Development Control
Ribbles Valley Borough Council

Re: Planning Application 19/0815

Address: Cooks Farm Further Lane Mellor BB2 7QB

Description: Proposed demolition of existing coal shed/plant room and construction of single-story extension linked to dwelling; proposed single-story, three-car garage and alterations to existing vehicular access.

drg.no. 1939 / 05 rev. C

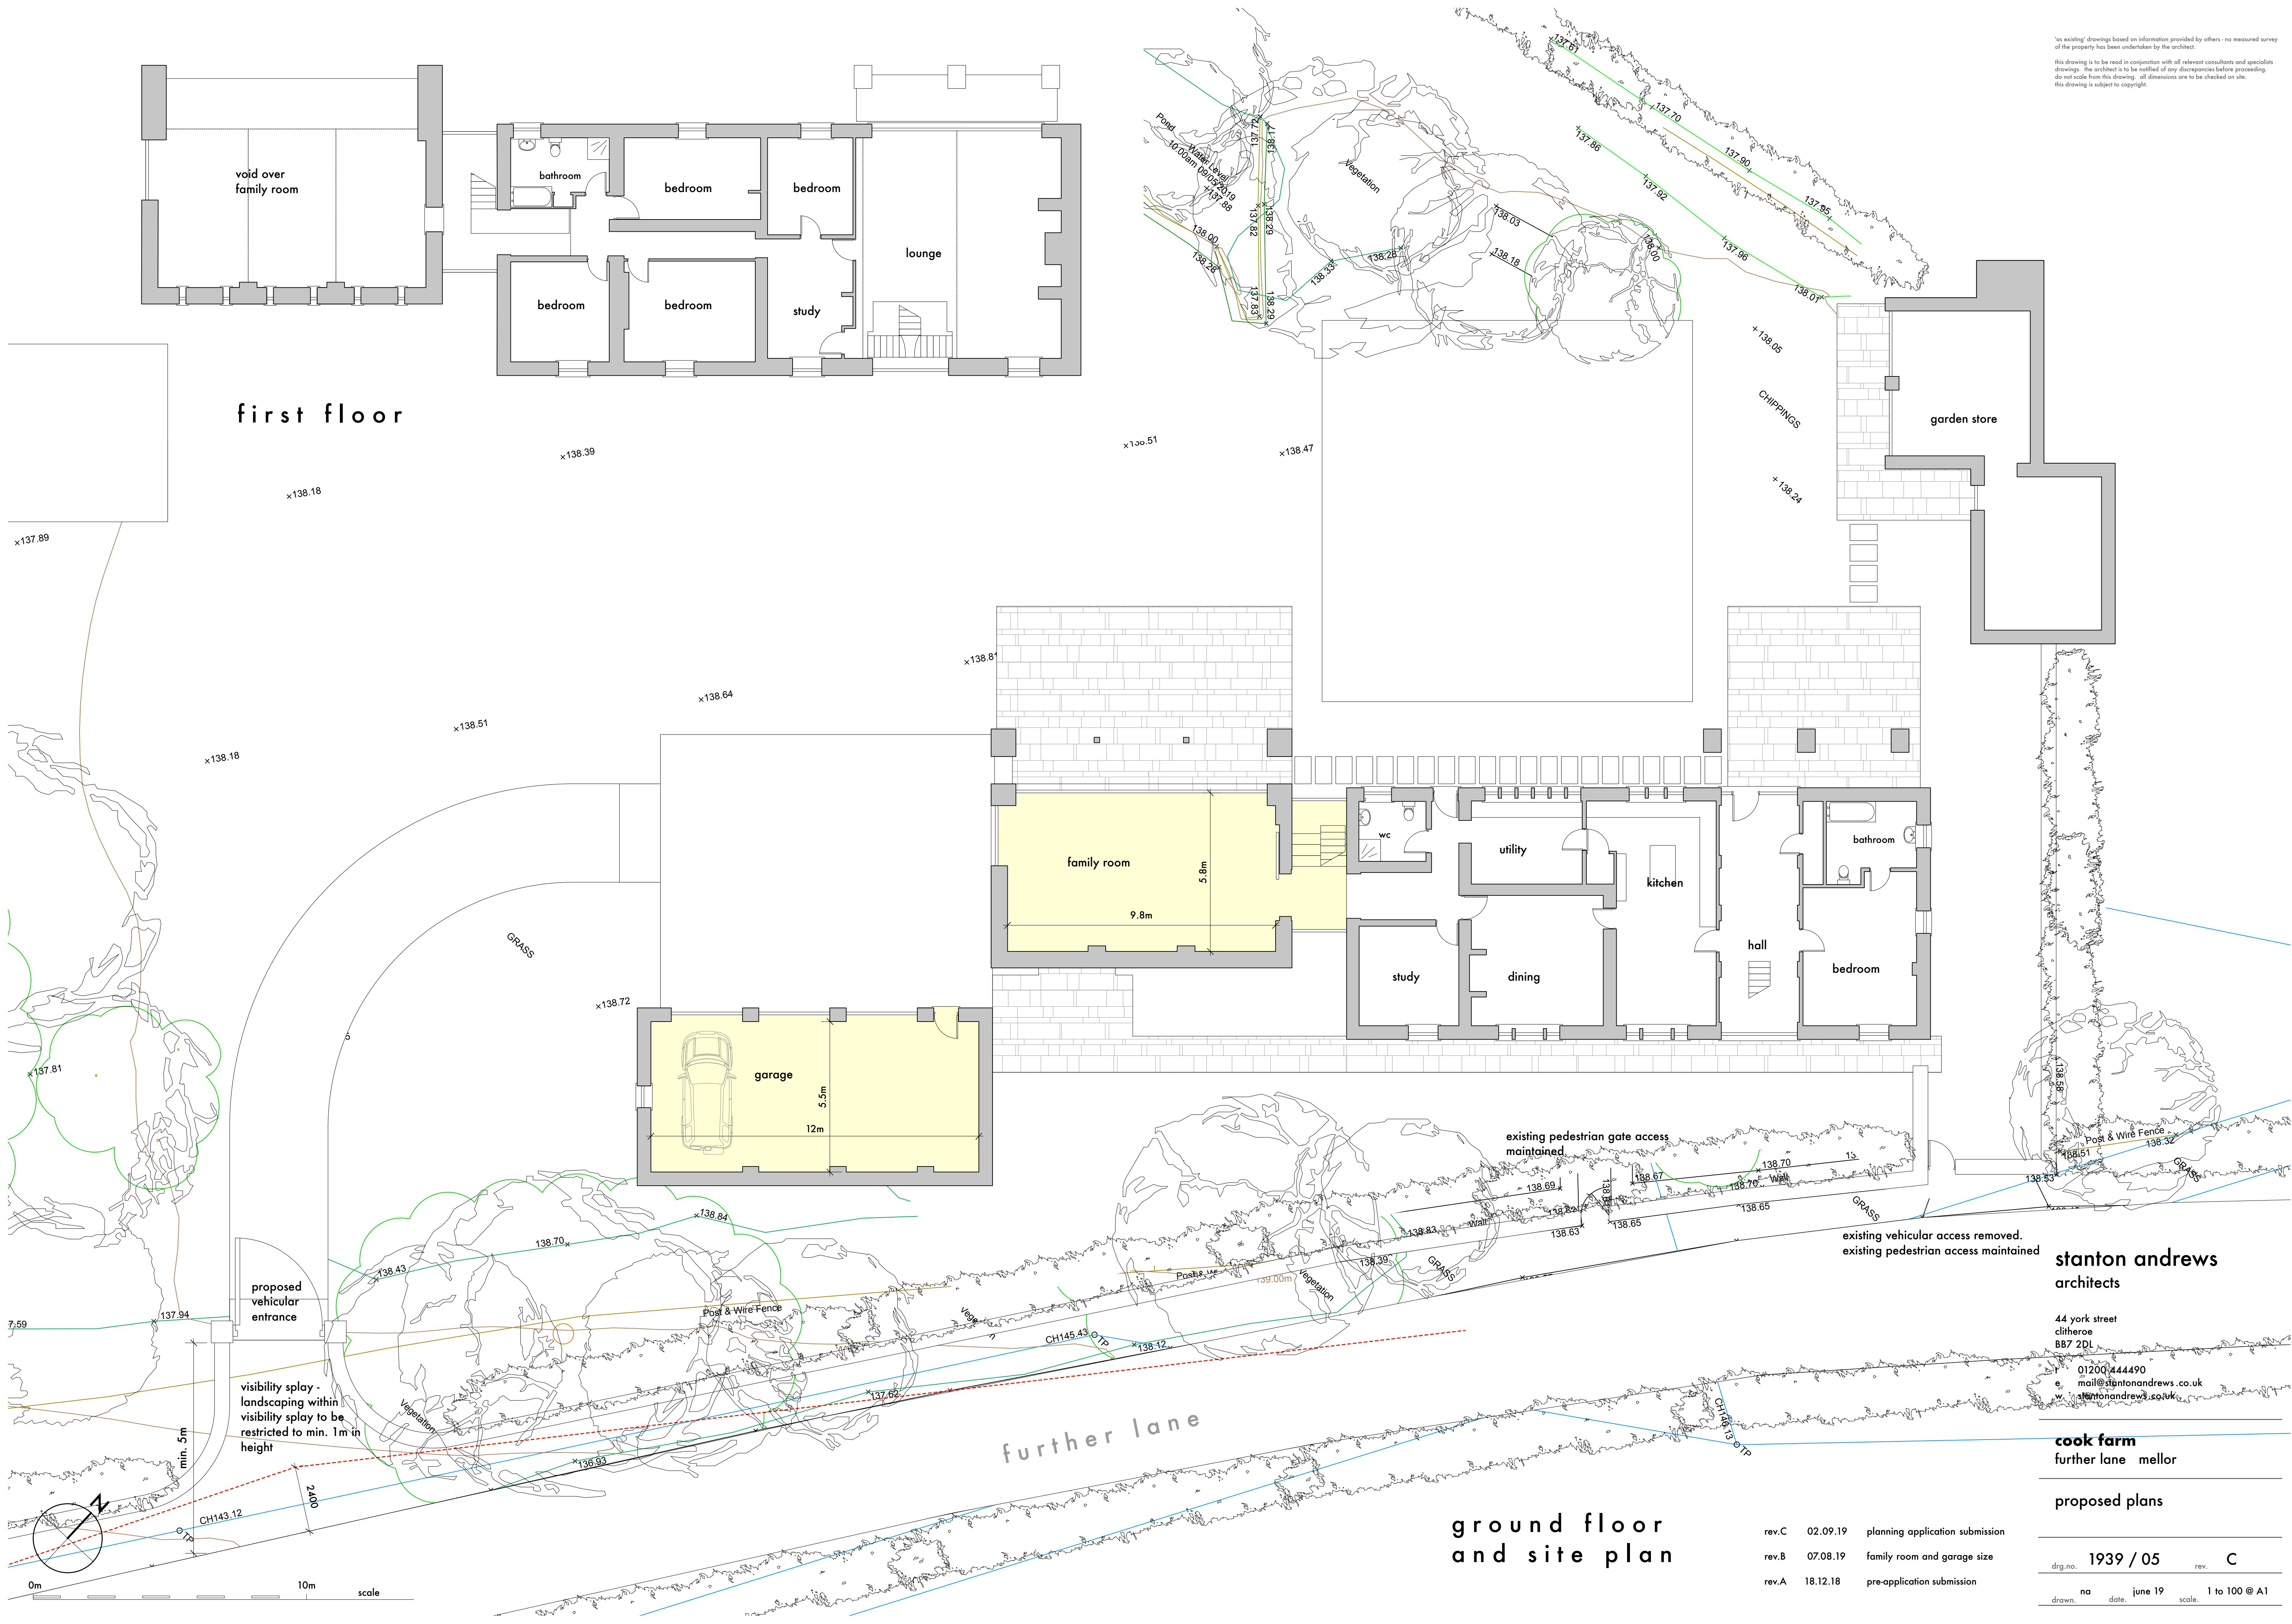
With respect to this application whilst we would have no objection to the principle of the works there is some concern regarding the access.

In order to progress the application we would look for a plan showing a larger visibility splay. The plans provided show a visibility splay in the region of 24m this would be appropriate on a road with a speed limit of 20 mph. A plan showing the full extents of the available visibility splay should be provided.

The posted speed limit on Further Lane is 60mph which would support a visibility splay of 2.4m x 215m. Initially we would look for a plan showing what the available splay is, this may be supported by an automated traffic count to ascertain the 85th percentile speed which is likely to be less than 60mph which would narrow the visibility splay.

1. Before the access is used for vehicular purposes, any gateposts erected at the access shall be positioned at least 5m behind the back edge of the carriageway. The gates shall open away from the highway. **Reasons:** To permit vehicles to pull clear of the carriageway when entering and exiting the site and to ensure the swing of the gates do not affect the availability for a car to wait off road.

2. All gates and associated mechanisms to be located outside the adopted highway and the gates to have physical restraints to prevent the gates from opening onto the adopted highway. **Reasons** to ensure the adopted highway is not obstructed by the gates or are a hazard to other road users.

3. The applicant should provide accurate details of the required sight line requirement, before determining the application, ensuring the entire sight line requirement is fully over land within the applicants control and/or over the adopted highway and to fully show all works which would be required to provide the sight lines. The sight line splays will require walls, fences, trees, hedges, shrubs, ground growth, structures etc. to have a maximum height of 1.0m above the height at the centre line of the adjacent carriageway.

4. The sight line splays will also require the overhanging tree branches, within the splays to be cleared to provide a minimum clearance of 2.4m above the height at the centre line of the adjacent carriageway.
